From: Clare Atkin [REDACTED]
Sent: 14 March 2019 10:45
To: Charlotte Easton
Cc: Andy Beetham
Subject: RE: The Locomotive, Wick (Refs; LU/301/18/L & LU/297/18/A)

From: Charlotte Easton <Charlotte.Easton@arun.gov.uk>
Sent: 11 March 2019 14:57
To: Clare Atkin [REDACTED]
Subject: FW: The Locomotive, Wick (Refs; LU/301/18/L & LU/297/18/A)

C TWO x new amenity boards.
Size 600mm x 900mm H.A.G 1.2m

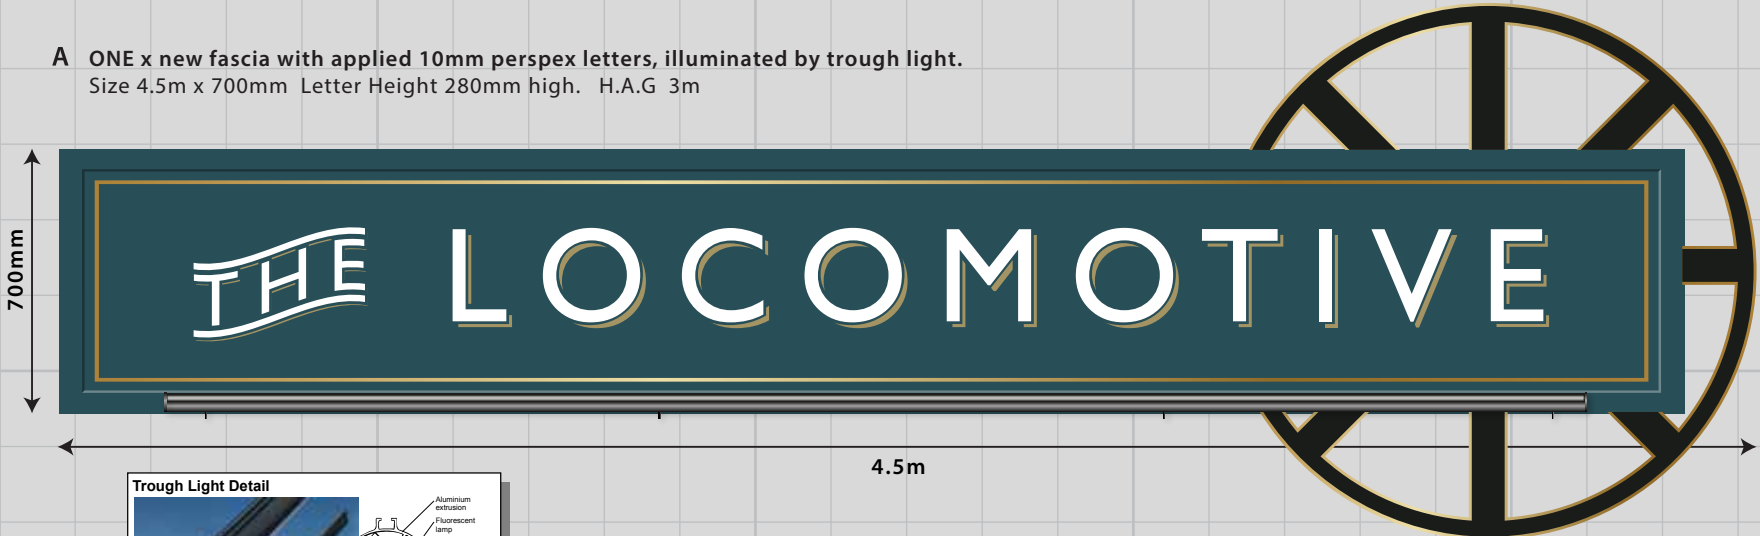
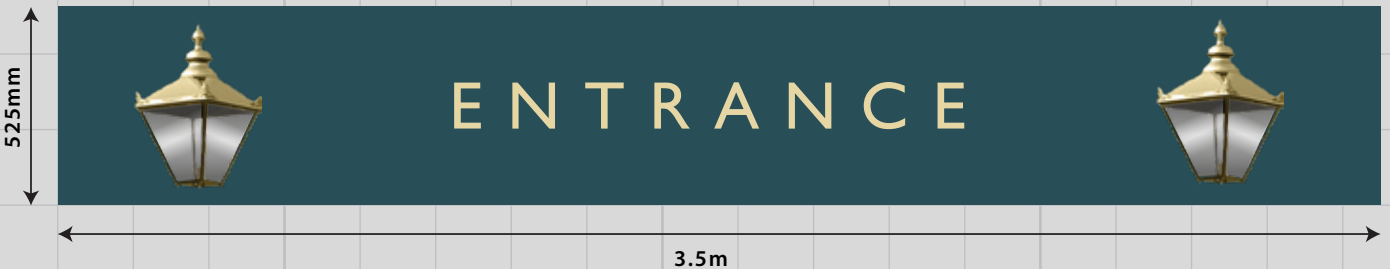
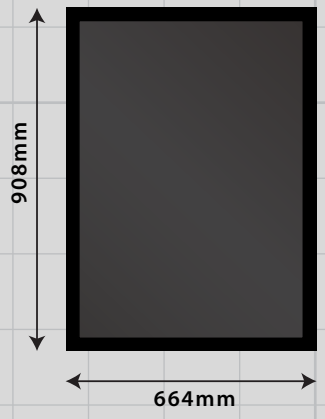
He has asked you confirm which type of board would be used, his preference would be image C as shown on the signage specifications?

I have spoken with the Conservation Officer again with regard to your email and he is still not happy with the 2No Amenity boards you have suggested. Would you like to remove the 4 No. Boards from your application?

He has also asked for the tone of the proposed lighting, i.e: white or other.

- Signs C & F – 4no signs would be excessive on this elevation – could we remove the 2no amenity boards, and retain Sign F.
- Sign H – These lights would be 30w LED fittings and would be positioned and angled in such a way to highlight the building and avoid any light spillage.

Yes, the proposed amenity to the front elevation would be as per Sign C. We would then apply a lockable poster case to the sign board (with frames painted to match the sign) with a permanent message behind them. This would give us the opportunity to display a permanent message, but with the option to display seasonal messages/offers as required. By painting out the frames to match the sign colour, from a distance, this would hardly be visible.
